Mr M Jones
15 Elm Grove South
Barnham
W. Sussex
PO22 0EJ
21st Oct 2012

**Ref; Planning application at 17 Elm Grove South – EG/59/12/
Laying permeable hard standing, A/C units and external lighting.**

TITLE SITE PLAN

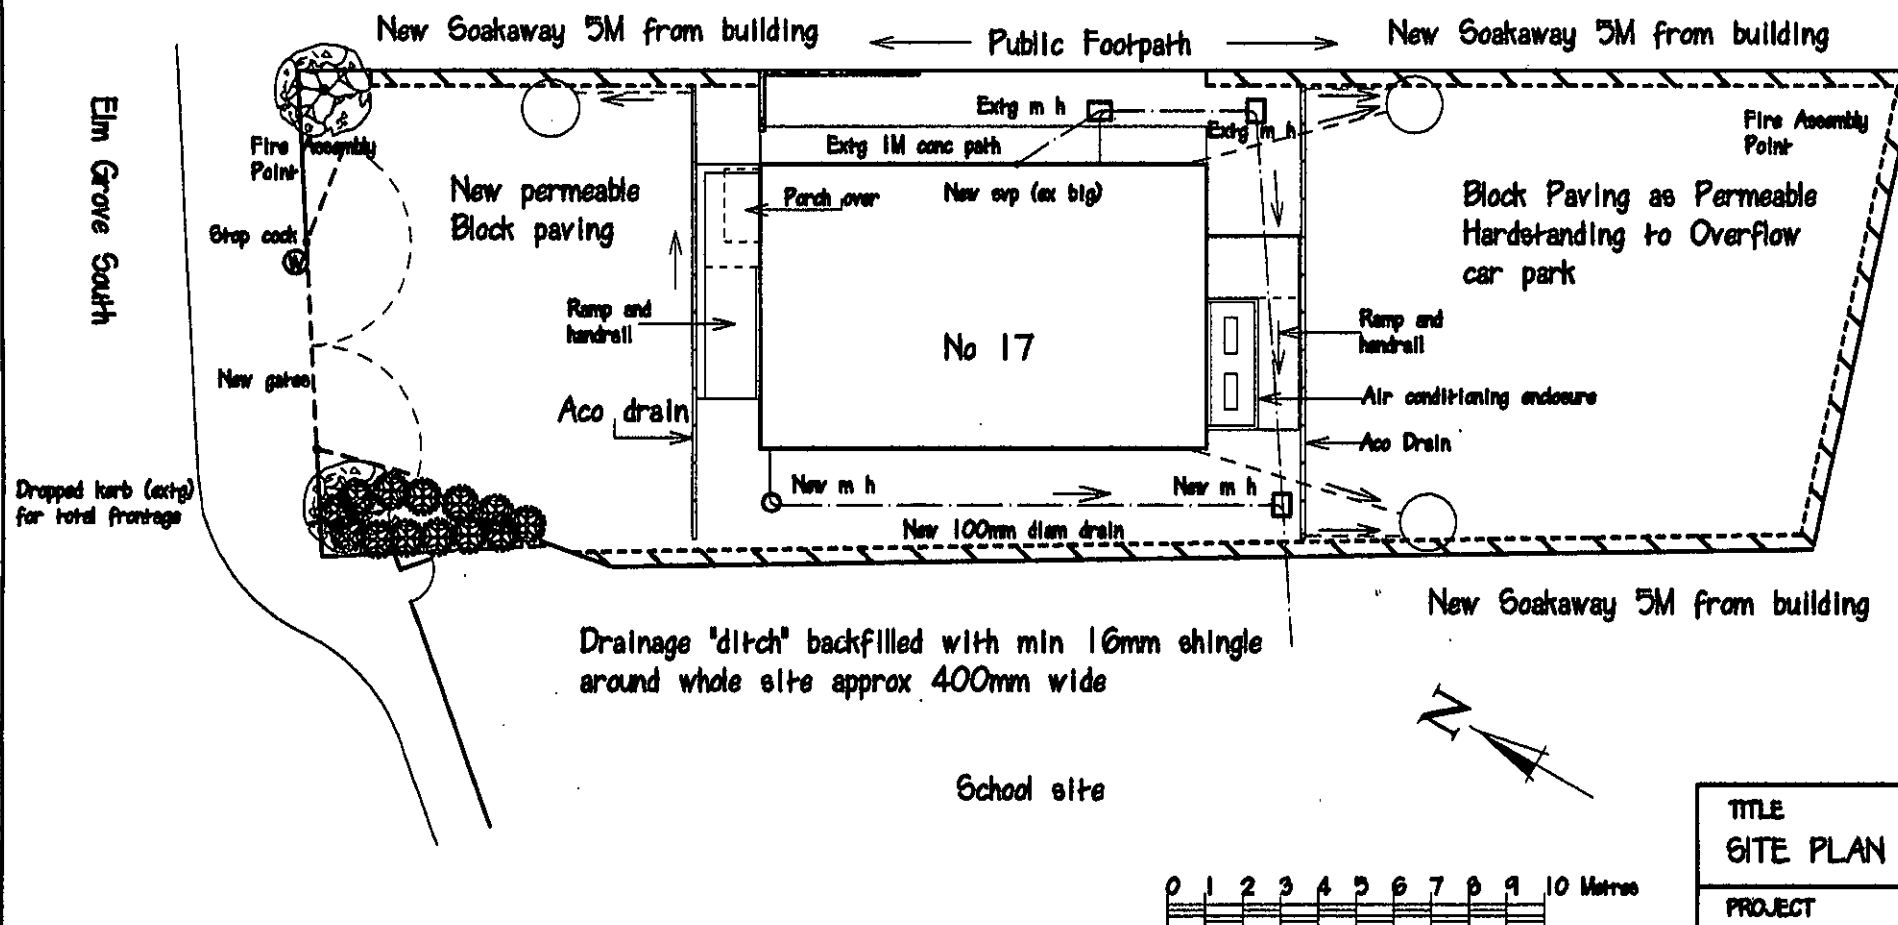
Inefficient surface water drainage provision and design. All soakaways are rubble (bricks) backfill and do not have sufficient capacity for the roof runoff and the hard standing.

Location of one of the soakaways has been placed within 2 meters of my garage building, this is not shown on the plan. This doesn't therefore fulfil the 5 meters from buildings rule for the location of soakaways.

Current material covering the site looks inappropriate (type1) for use as a part of a permeable surface construction in accordance with the Environment Agency 'guidance on the permeable surfacing of front gardens' document.

Details of surface water management are not sufficient, no percolation tests and no provision for the 1:100 rain storm event.

The application states 8 to 20 cars to use the site. Despite point 2, access issues, there is insufficient space to allow for that number of vehicles on the site and to safely move, turn and exit.

Full plans showing vehicle route within the site and parking plan should be requested.

The property had mature trees, bushes and a large conifer hedge to screen the school from local residents. They have all but a few been removed as part of this redevelopment. The plans do not propose any form of planting or screening at the rear of the property. This leaves this development out of keeping with the local area.

TITLE PROPOSED FLOOR PLAN (Ind Exits, Ramps & Air Con)	
PROJECT ELM GROVE SOUTH GOSPEL HALL BARNHAM PO22	
CLIENT BOGNOR GOSPEL HALL TRUST	
DRAWN SCALE DATE DRAWING NO AMENDMENTS	R HOLLANDS 1 : 100 @ A4 AUGUST 2012 12-08-GD-131-09A (A) Rear ramp revised

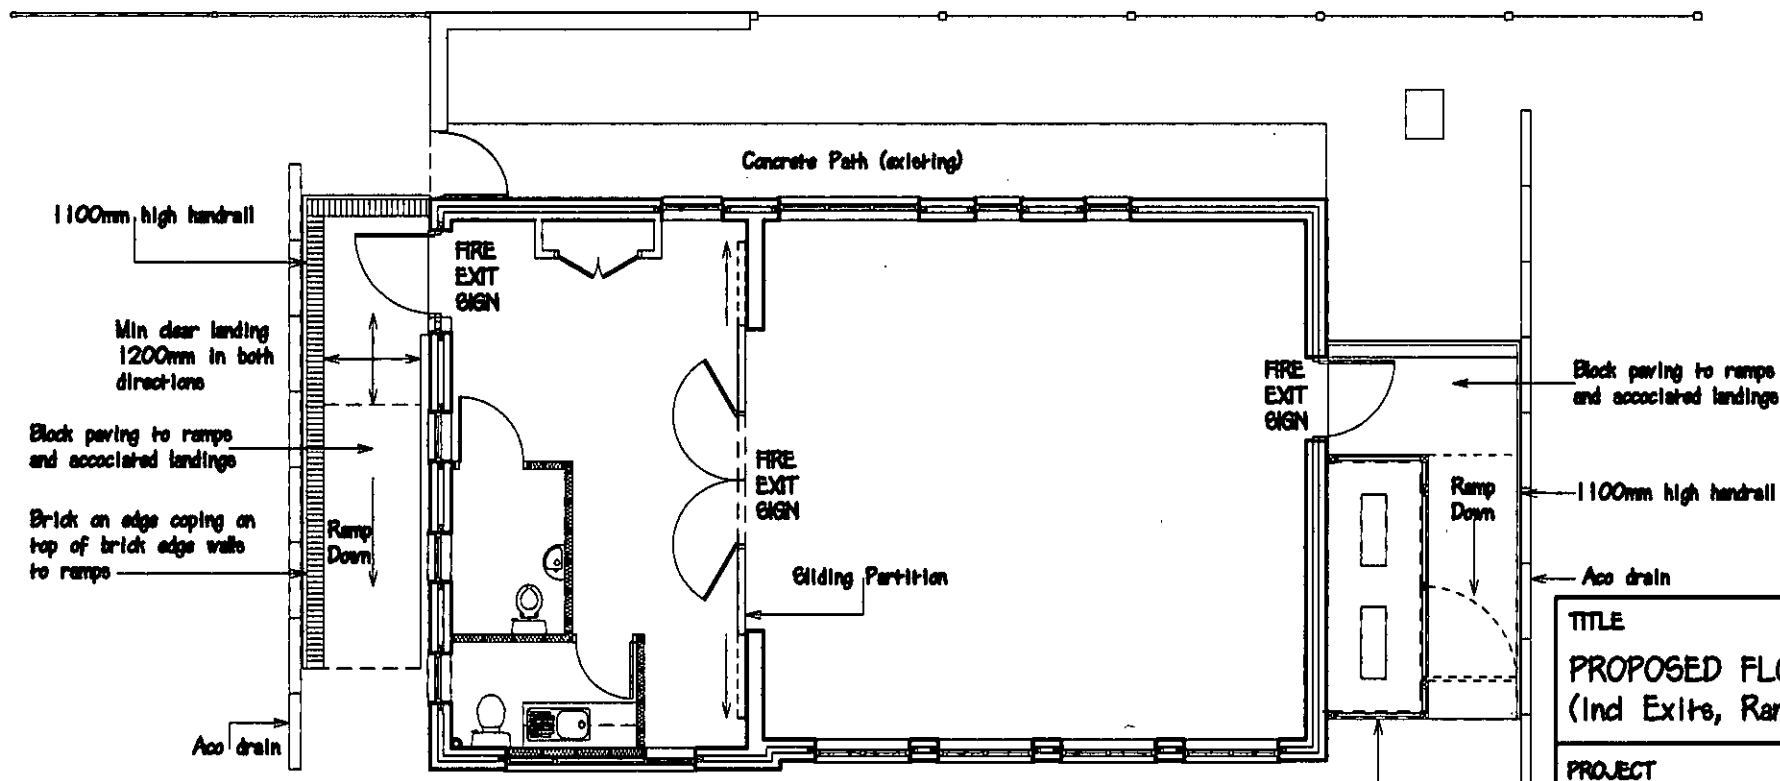
I am concerned that the position of the air conditioning units will generate unnecessary noise pollution. Air conditioning units do not generate a constant sound but rather cut in and out at will. The positioning of these units is not of least impact. The proposed use of hit and miss fencing offers no guarantee that this noise will be stopped. Moving the units to the school side of the property would be best as during the periods of use, the school is not in use and the noise would be deflected away from the residential properties.

The use is stated as evenings and weekends, I am concerned the noise will cause distress during use to me and my family during these times.
